Re: Objection to MP08_0244 MOD 1 Modification Request for Mixed Used Development at 23-37 Lindfield Avenue and 11 Havilah Lane, Lindfield

As a resident of Lindfield, I/we wish to lodge an objection against the proposed Modification of the subject development based on the following grounds:

1 SHADOW DIAGRAM - 21stDEC_9AM
5003 SCALE1 : 650

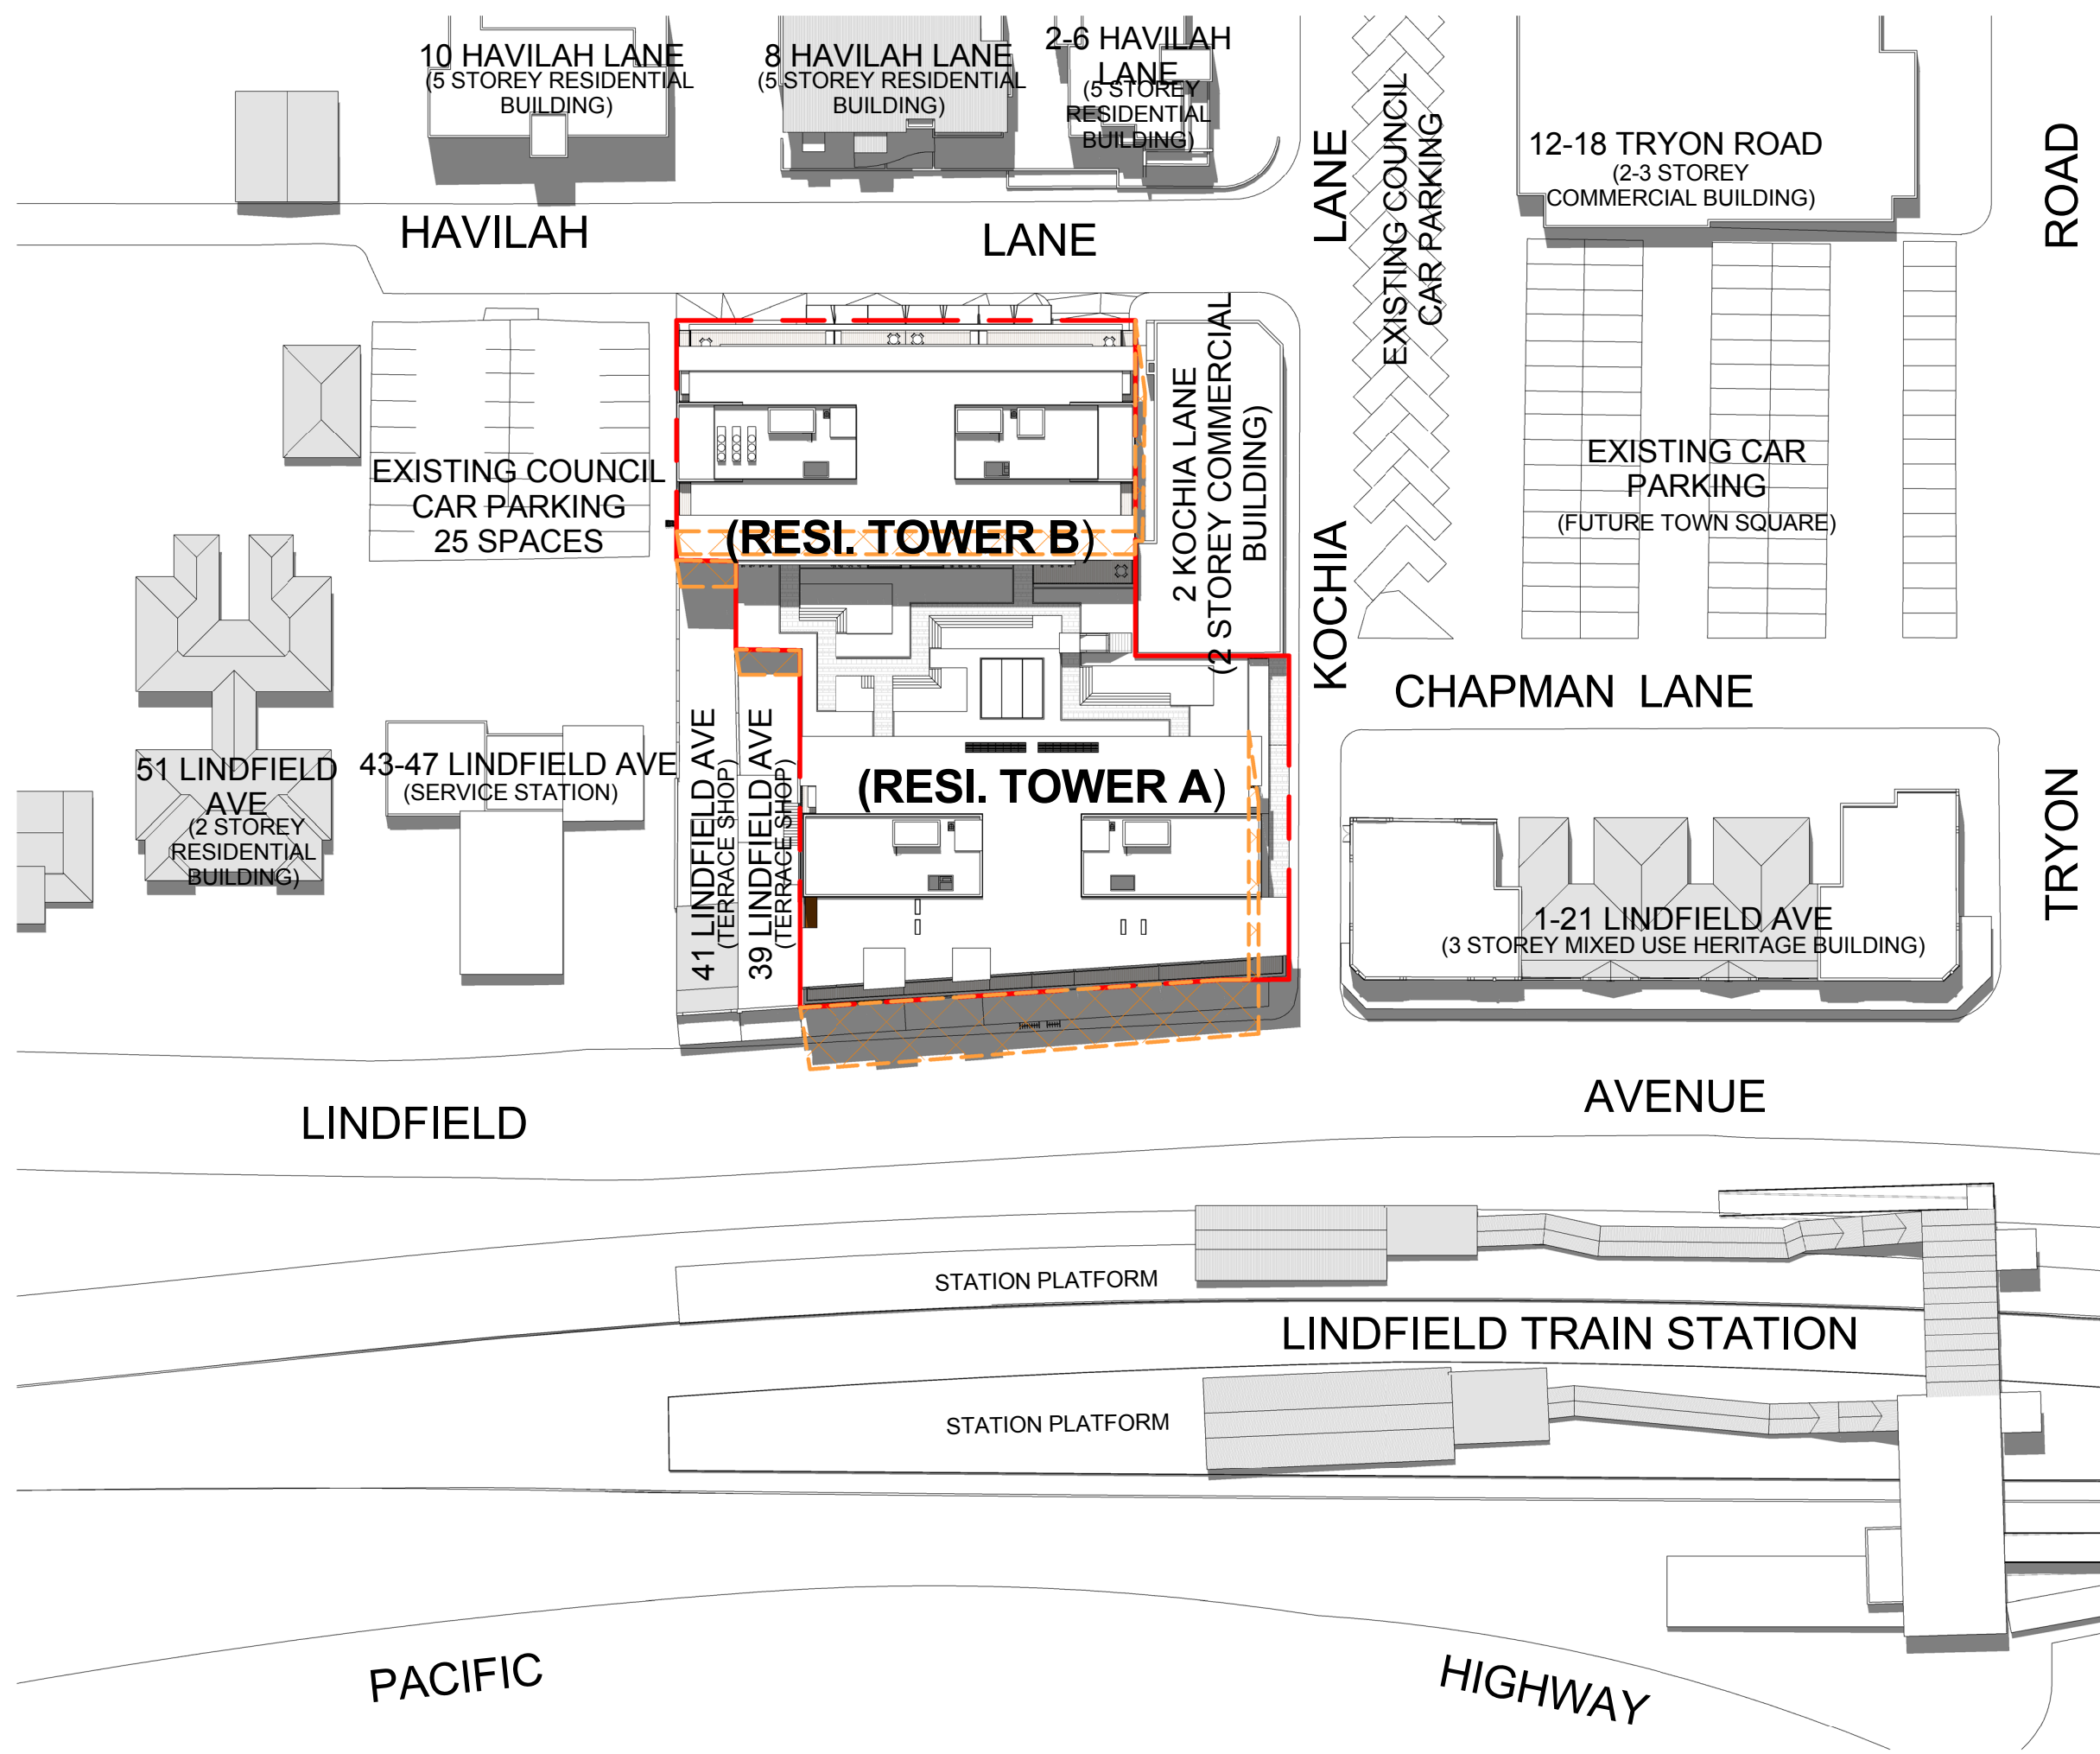
- The additional storeys create new adverse shadowing: a) for residents in the Havilah Lane apartments, particularly after 3pm b) for the popular outdoor café and central Lindfield hub area at 12 Tryon Road in afternoons, particularly in winter and c) for all commuters on the city bound Lindfield rail platform, instead of 50% of the year as approved, it will now be in shadow in the mornings 75% of the year
